**KIRKLEES METROPOLITAN COUNCIL
INVESTMENT & REGENERATION SERVICE**

DELEGATED DECISION TO DETERMINE PLANNING APPLICATIONS

Reference No:	2024/62/90905/E
Site Address:	21, Summerbridge Crescent, Gomersal, Cleckheaton, BD19 4LW
Description:	Erection of front, side and rear extensions and alterations
Recommending Officer:	Jennifer Booth

DECISION – Conditional Full Permission

F R O N T

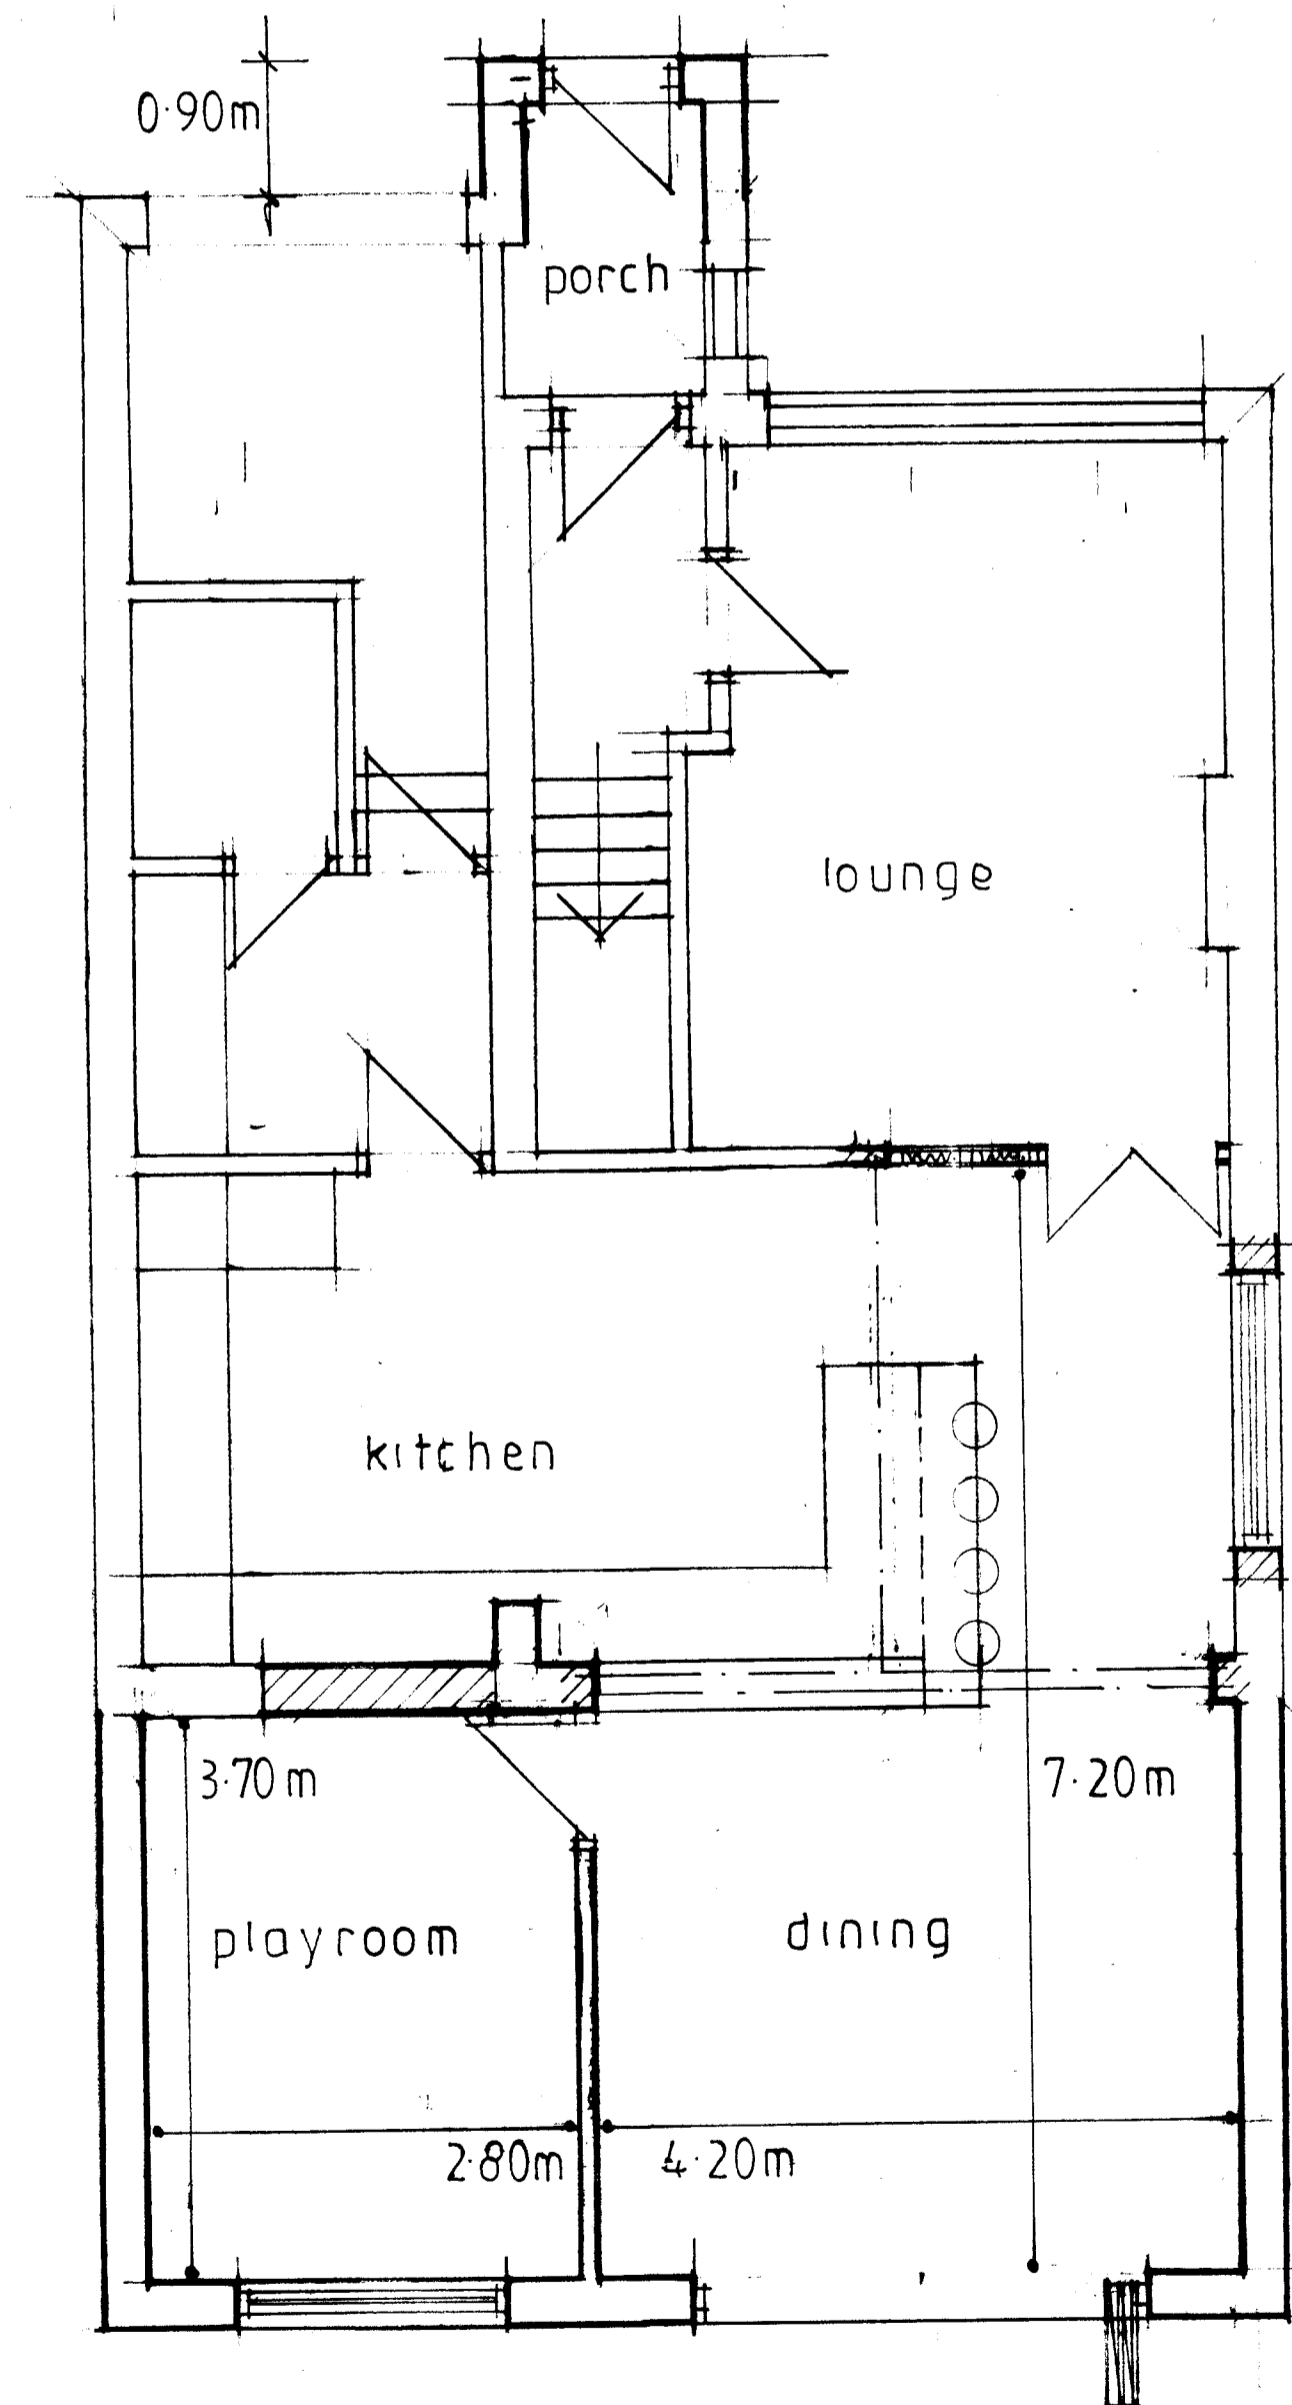
The plans as originally submitted raised concerns in terms of the potential impacts of a 2 storey extension with a projection of 4m on the adjacent dwelling. Amended plans were sought and received which reduced the projection at first floor to 3m. As the alteration reduced the scheme, the amended plans have not been advertised.

The rear extension would project 4m on the ground floor, reducing to 3m at first floor. Given the separation provided by the drive of the adjacent property together with the garage, the extension would result in negligible overshadowing or overbearing impact. The windows in the rear elevation would not result in any additional overlooking over and above the existing arrangements on site.

The neighbouring property occupies an elevated position relative to the neighbouring property and there is a lack of direct alignment together with significant angling between the properties. The side and rear extension would increase the bulk along the shared boundary with the adjacent bungalow. However, the first floor side extension aligns with the front corner of the neighbouring property. Furthermore, the spatial relationship between the properties mitigates against some of the impacts.

The plans initially submitted raised concerns in terms of potential impacts of a 2 storey extension with a projection of 4m on the adjacent dwelling. Amended plans were sought and received which reduced the projection at first floor to 3m. As the alteration reduced the scheme, the amended plans have not been advertised.
